From: Brian Banister [REDACTED] >
Sent: 14 October 2025 14:20
To: Planning.Responses
Subject: Arun Conservation Area Advisory Panel comments on applications

The **Arun Conservation Area Advisory Panel** wish the following comments to be taken into consideration in the determination of the applications:

FP/135/25/PL - The Fox Inn, Waterloo Road, Felpham

## The Fox (Amended designs in white)

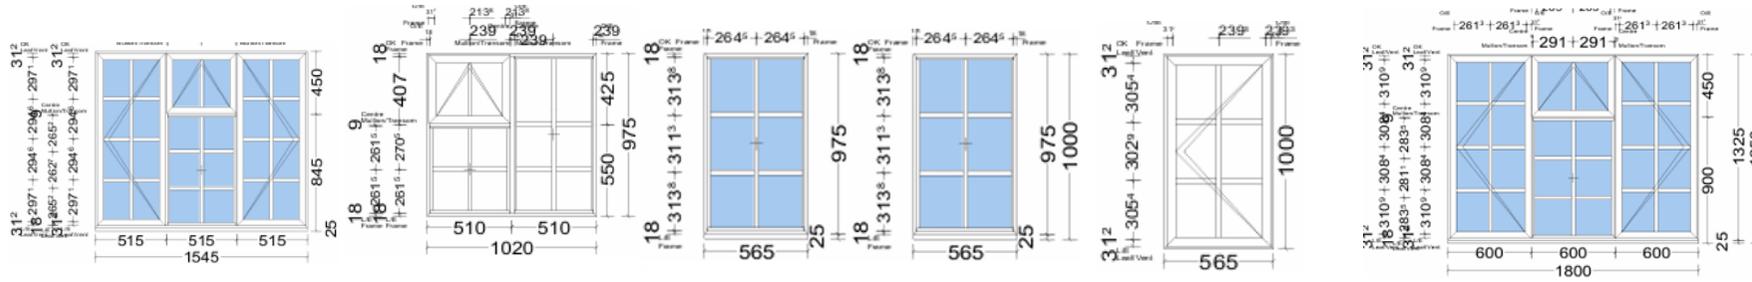
However, the existing metal windows are very important features of the building and it is considered that a condition survey should be submitted as part of the application. Repair rather than replacement should be the aim and secondary glazing could be undertaken in order to improve thermal efficiency.

On the street elevation, if the first floor windows need to be replaced then the glazing pattern needs to match the existing. As an example, the top hung quarterlights need the introduction of a central, vertical glazing bar. The existing full depth side hung casements need to be replaced in the same configuration.

The bow window is a particularly fine feature of the front elevation of the building. The existing fenestration is curved to match the curve of the cornice and it will appear clumsy and inappropriate to introduce straight sections of window frames. There is a strong case here to retain the existing windows if replacement precisely as existing is not proposed.
